**RE: Response Letter
Meridian Service Metropolitan District
Interim Storage Area
Commercial Over-the-Counter Permit Request**

The purpose of this letter is to respond to comments provided on 10/19/20 which are as follows:

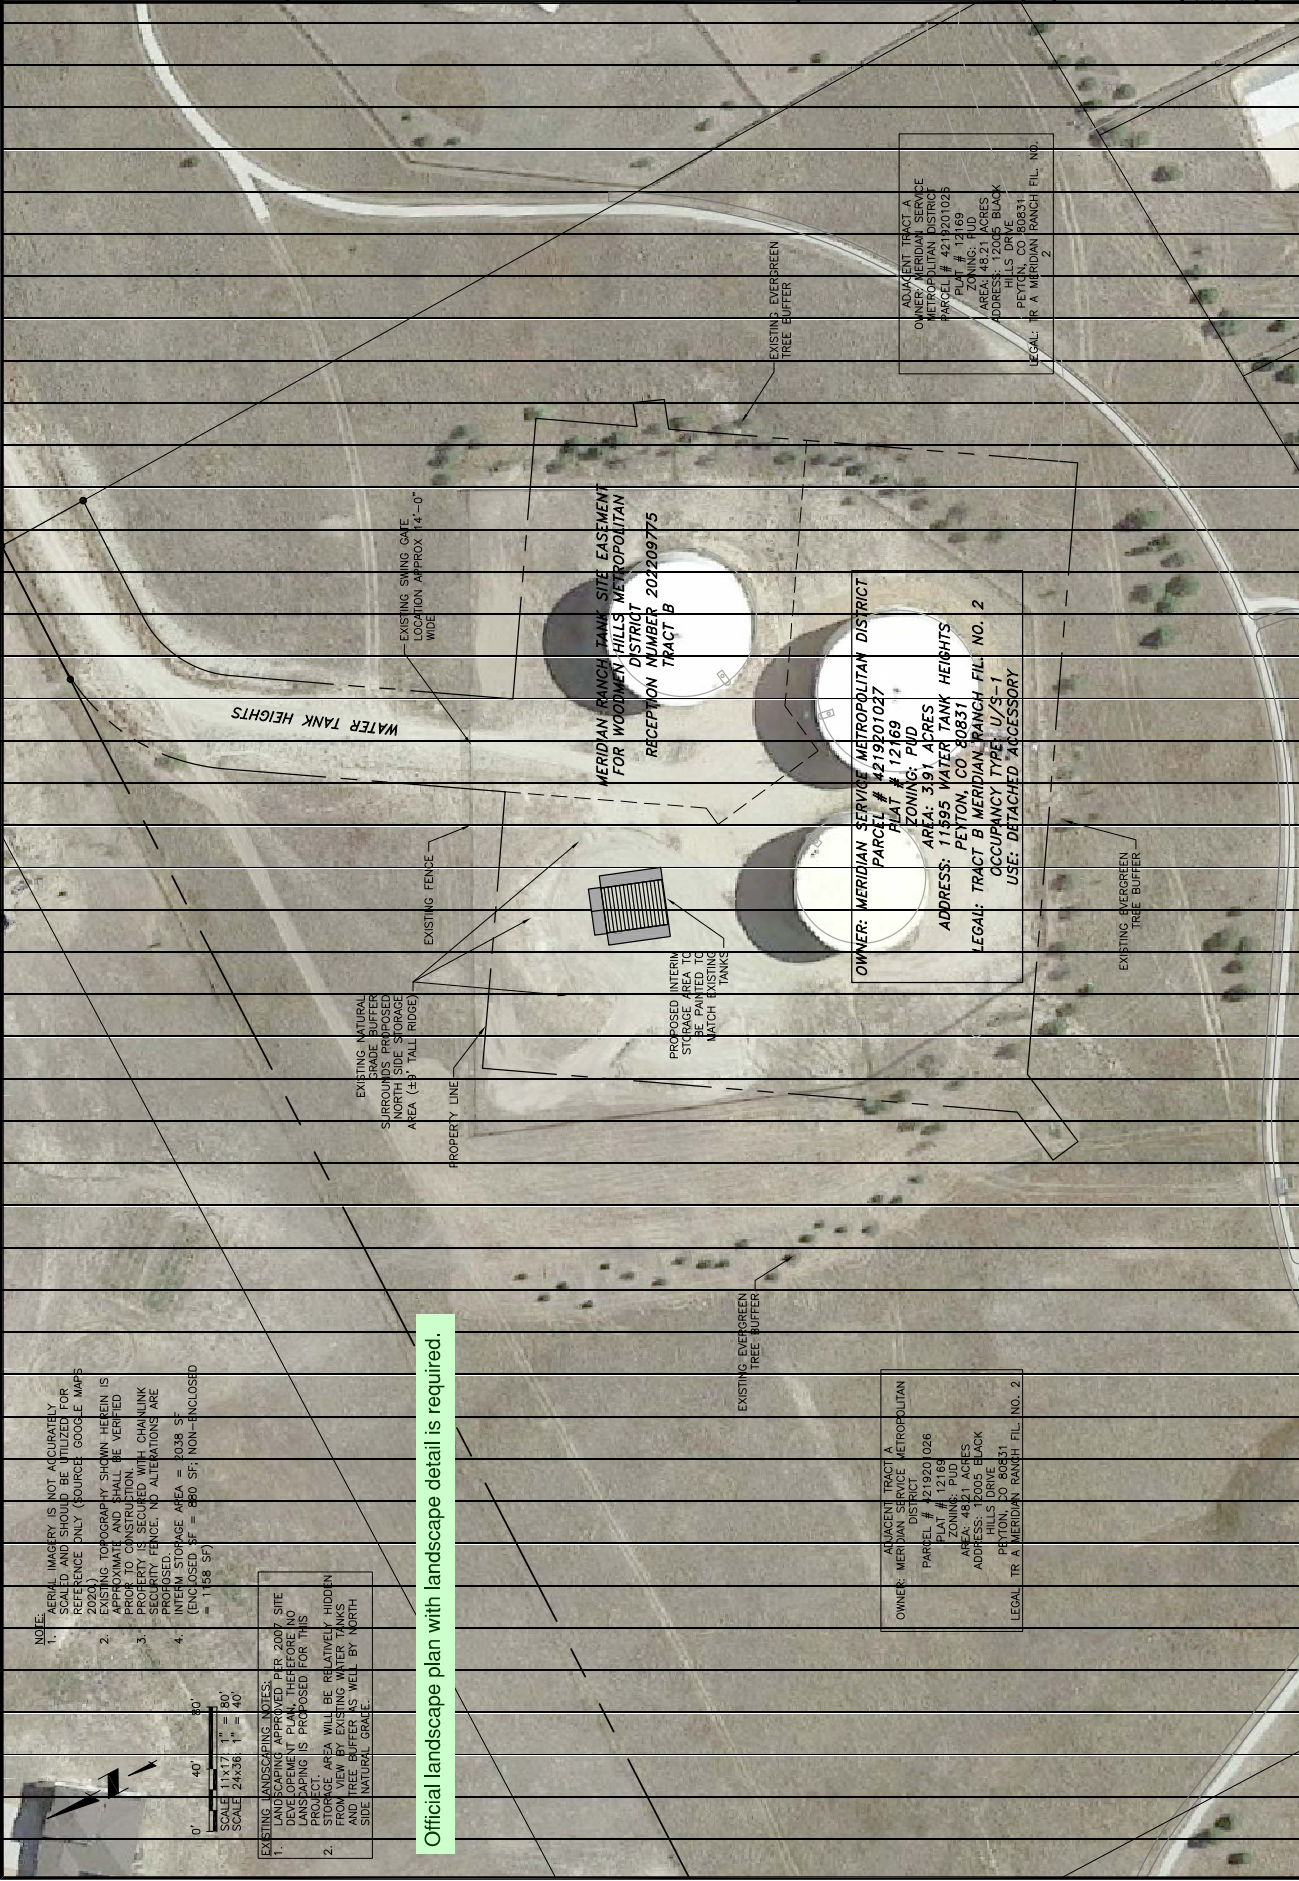
Official landscape plan with landscape detail is required.

Per our subsequent phone conversation, it was stated County approval could be considered if evidence can be provided affirming Chapter 6 of the Land Development Code is still being met with existing landscaping in place. We can attest the existing landscaping does not comply with Chapter 6 in its entirety and therefore, we are requesting consideration for partial landscaping exemption based on the following justification.

1. Reiteration of the 2007 tank build-out approval of the site must be made, despite the fact landscaping was not installed per the original drawing plan. The utility, a municipal Tract serving roughly 7,500 residents can be defined as governmental service infrastructure.

Existing landscaping to-date consists of buffer zones along the site's east, south, and west sides. These buffer zones contain established Ponderosa Pine landscaping, totaling roughly 72 trees which are spaced 15'–20' apart. As previously stated, as well as depicted, the north side of the proposed storage area will be concealed by natural grade (9' +/- tall ridge). It will also be painted to match the existing tanks.

2. It has been proven that excess landscaping deters access and maintenance for utility infrastructure.

Due to the nature of this facility (serving public health and safety) and due to requirements from other permitting agencies, the site cannot adhere to EPC regulations for landscaping. Additional reasons include:

- No obstructions can impede access to critical equipment (i.e. backup generator, emergency storage tanks, building access, bypass pumping locations, etc.)

- No permanent structures can be placed over utility facilities (i.e. piping, valves, storage tanks, etc.)

The District is proposing that the landscaping shown on the “Existing Landscaping Plan” be sufficient as an alternative to satisfying requirements.

3. The Tract site was platted and then exempted in 2006 and is classified as an Exempt Political Subdivision. It is surrounded by 48.21 acres of the District’s own property which is also a Tract. The northeasterly water tank was approved in 2002, as was the tank located on the southwest portion of the Tract. The third tank to southeast was approved in 2007 as earlier indicated. Furthermore, *Rules Governing Division of Land, Chapter 7 or the Land Development Code, Section 7.2.2., (C) Exemption Lot and Parcel Design Standards (1) Comply with LDC* states:

The resulting lots or parcels shall comply with the LDC unless: (1) a waiver or variance of one or more of the provisions of the LDC has been approved; or (2) the lots or parcels are for community facilities including utilities.

Part (2) of the aforementioned Section applies to the site, including the existing tanks and specifically, the proposed detached accessory temporary storage area.

4. Security is always at the forefront of design consideration for a municipal District. As of June 2002, the municipal Districts must comply with the Federal Government’s Vulnerability Assessment Act, also known as the Bioterrorism Act. The Homeland Security recommends that no object should obstruct a utility facility’s view, in order to facilitate security. Therefore, the previously approved 2007 tank site landscaping was reconsidered and not installed per plan. Additionally, the Federal requirement does not allow the Homeland Security’s constraints to be made public.

To reiterate, no object should impinge upon a utility facility’s view and thus the planting of additional landscaping surrounding the site per *LDC Chapter 6*, which could obstruct security’s view of the site from the street, is not recommended. As previously mentioned, the District has, however, utilized landscaping where possible without compromising security requirements. The north side of the site was specifically left open (and approved) in order to reduce obstructions.
